August 22, 2007

RE: Estates of Longfellow Inn, 130 Eastern Promenade, (Application ID # 2007-0123)

Thank you for your application for a proposed renovation and building addition at 130 Eastern Promenade. Staff review of your application submissions has generated the following comments:

PLANT SCHEDULE

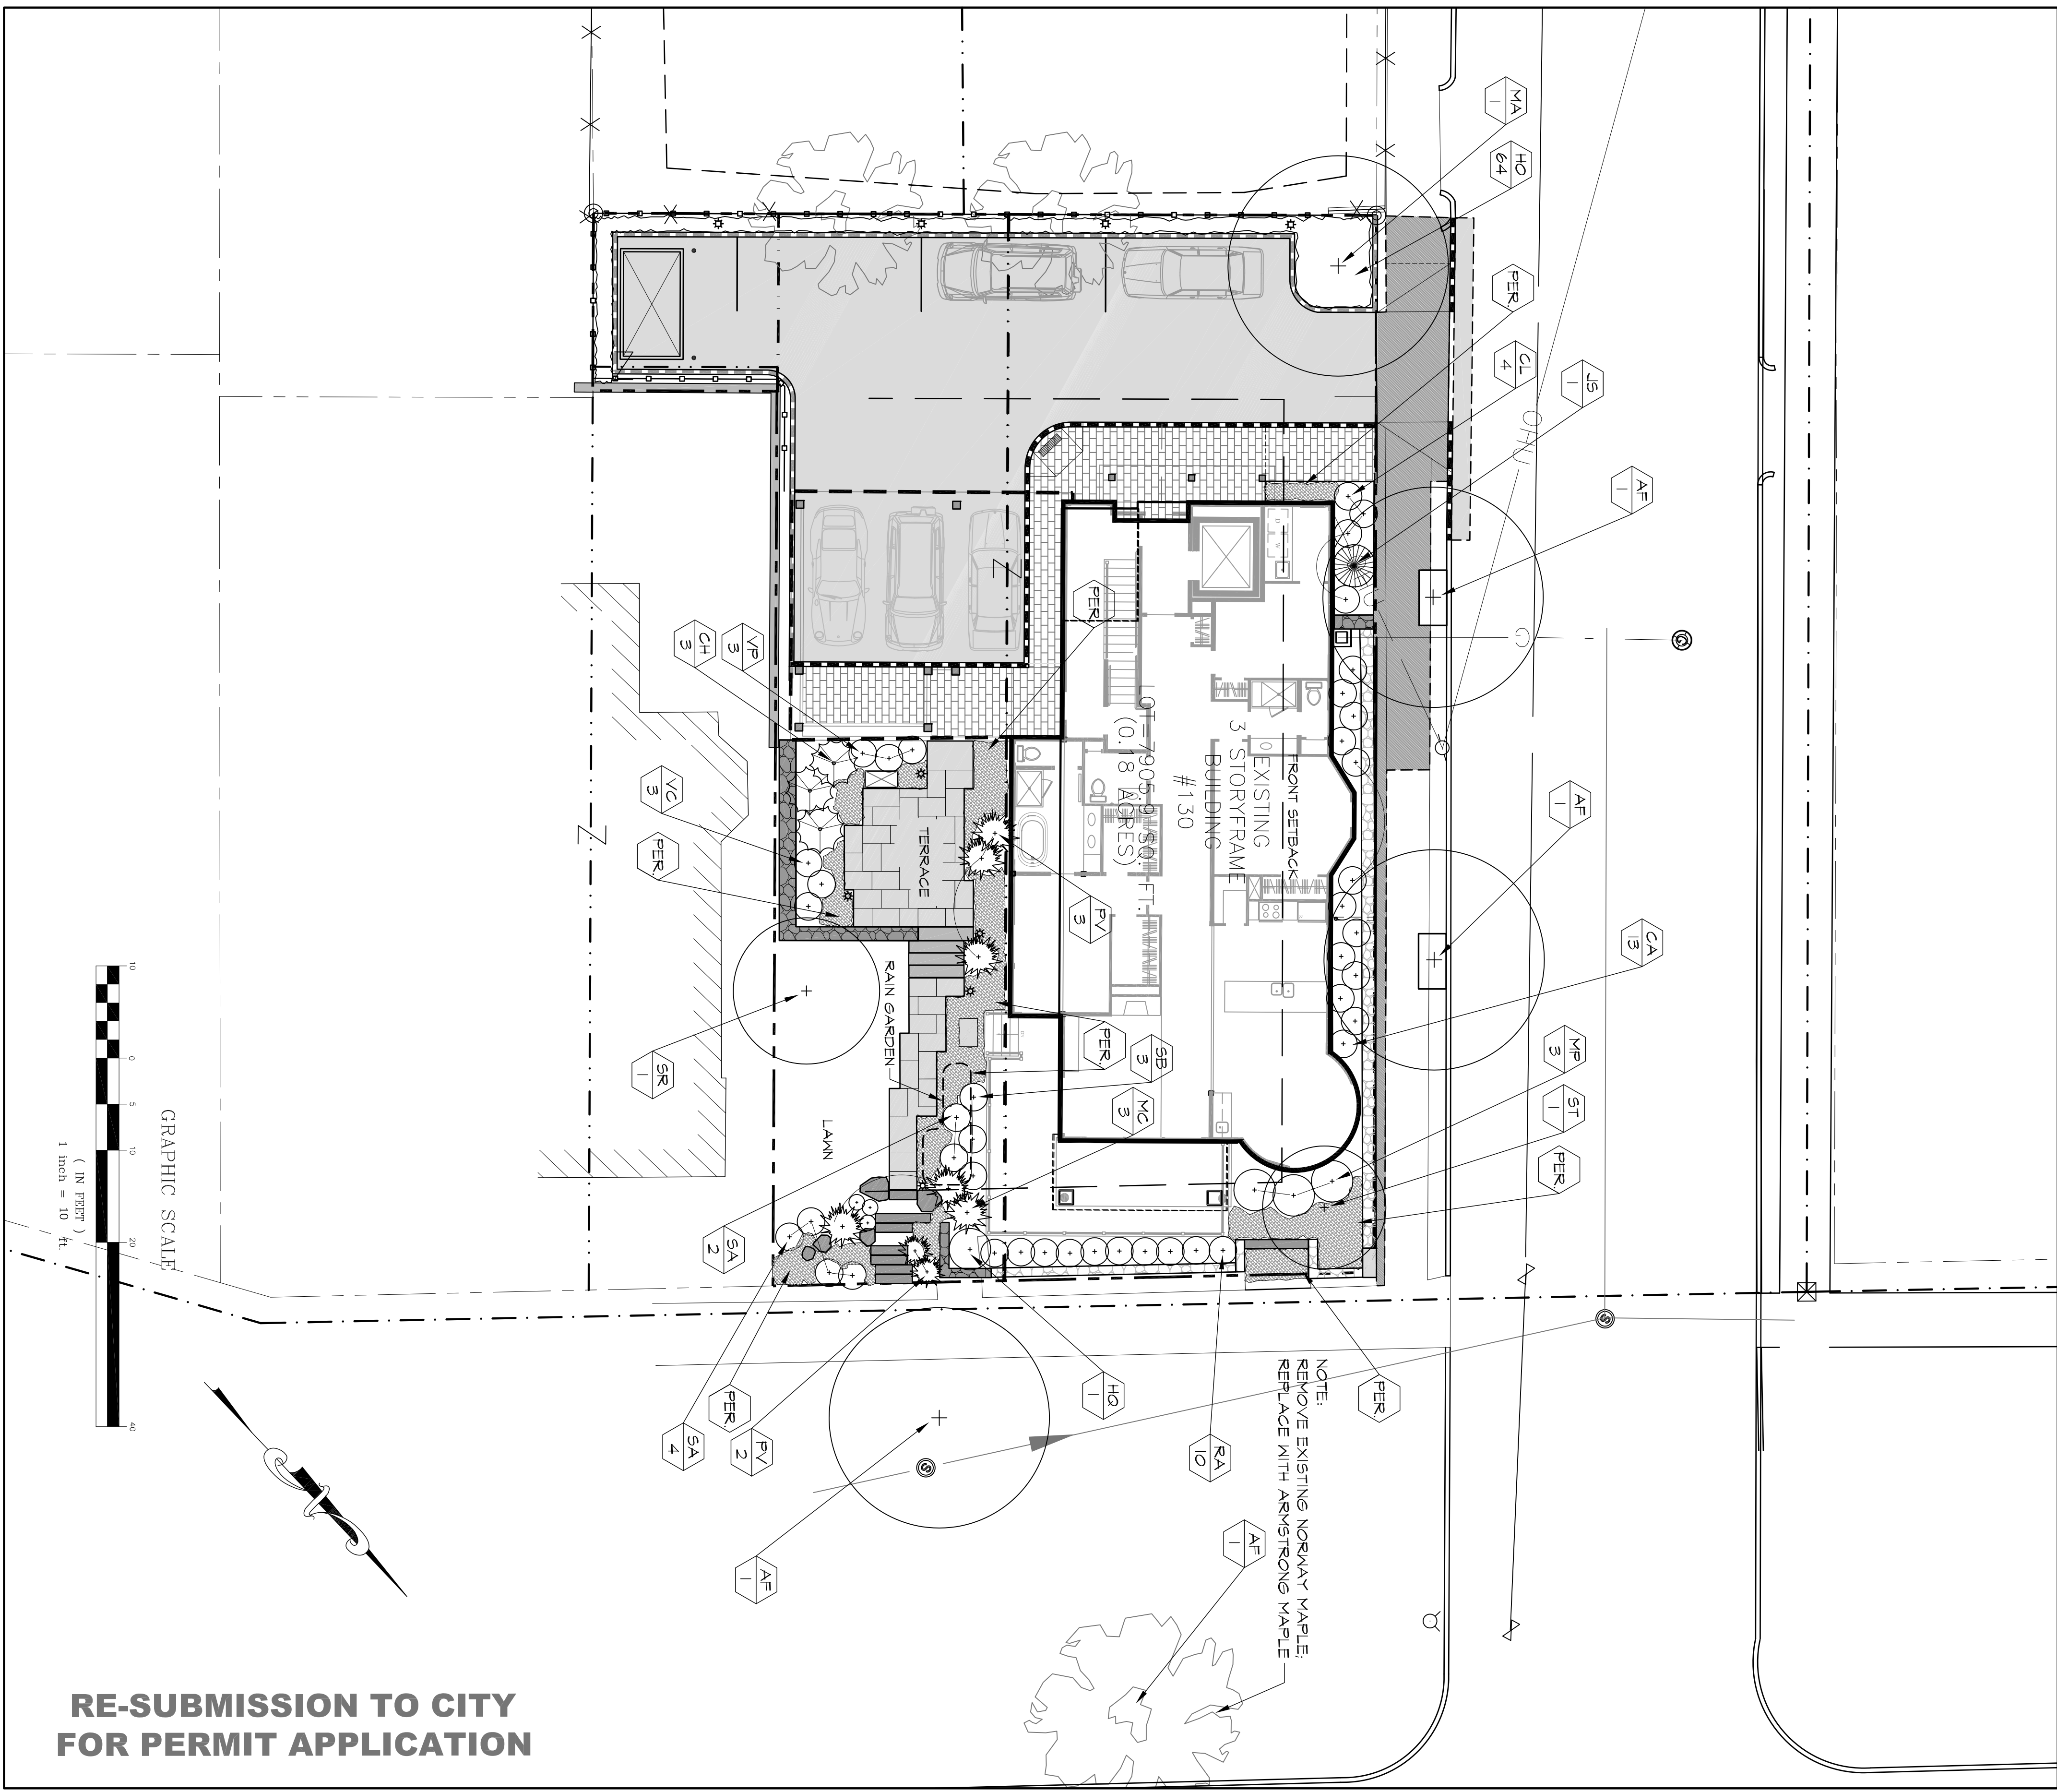
- a. The proposed amount of landscaping is insufficient. Proposed landscaping at the front of the development should be extended along the entire frontage above the existing stonewall. It should continue, wrapping around the building, on the Wilson Street side above the existing granite wall. Jeff suggests incorporating ornamentals such as dogwoods in these areas.

- b. Historically, there were two elms growing on the existing sidewalk and esplanade, along the frontage of the project area on the Eastern Promenade. In order to fulfill the goals of the Eastern Promenade Master Plan, which seeks to restore and preserve the historic landscape of this area, one of these elms should be replaced in this location along the esplanade. In order to preserve water views from the proposed development, it would be acceptable to remove the two existing norway maples along the frontage of the project area on the Eastern Promenade, and replace them with two elms in the same locations.

- c. Please include one street tree along the Wilson Street side of the proposed development. This tree should be either an armstrong red maple or an upright english oak.

- d. The proposed parking area requires visual screening between it and the parking lot on the abutting property along Wilson Street. The plans describe an existing chain link fence along the length of the proposed parking area; however, this fence does not exist on site. Please include a buffer to provide visual screening along the length of the proposed

parking. Jeff Tarling suggests either a line of arborvitae between the existing elm tree and maple trees or a 6' wall with vines between the two trees. These two trees should be maintained and temporary measures to preserve them during construction activity should be described on the revised plans.

5 REINFORCED CONCRETE SIDEWALK DETAIL

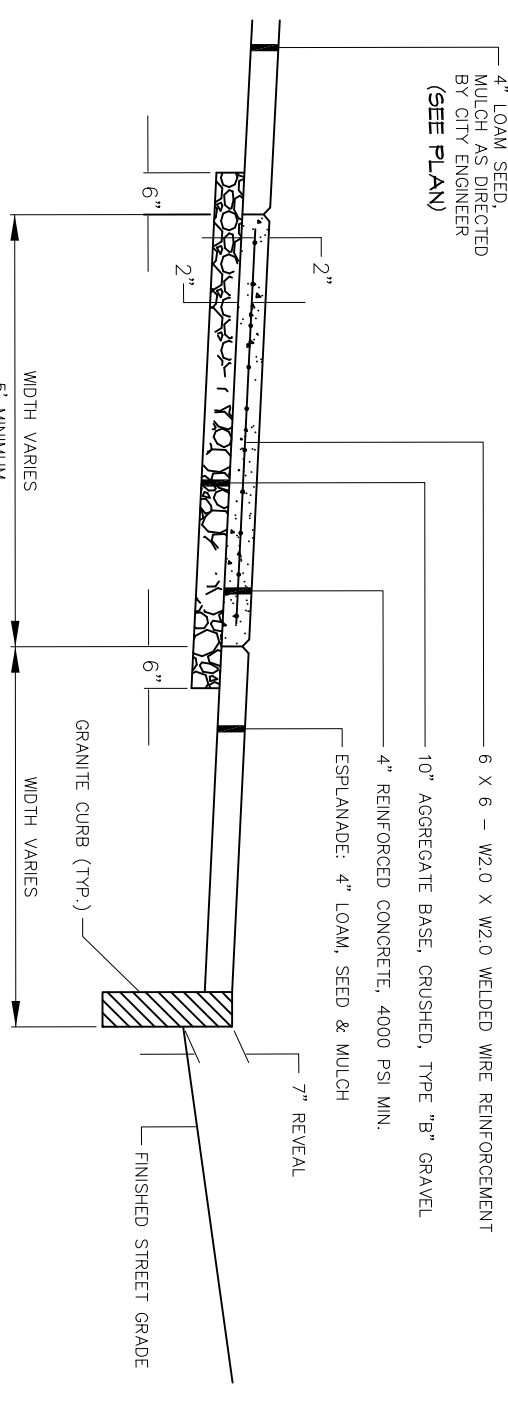
5. No details have been provided for the concrete sidewalk repair, the section of pavers to be installed at the northwestern corner of the building, or for connections to existing utilities. Please provide this information on revised plans.
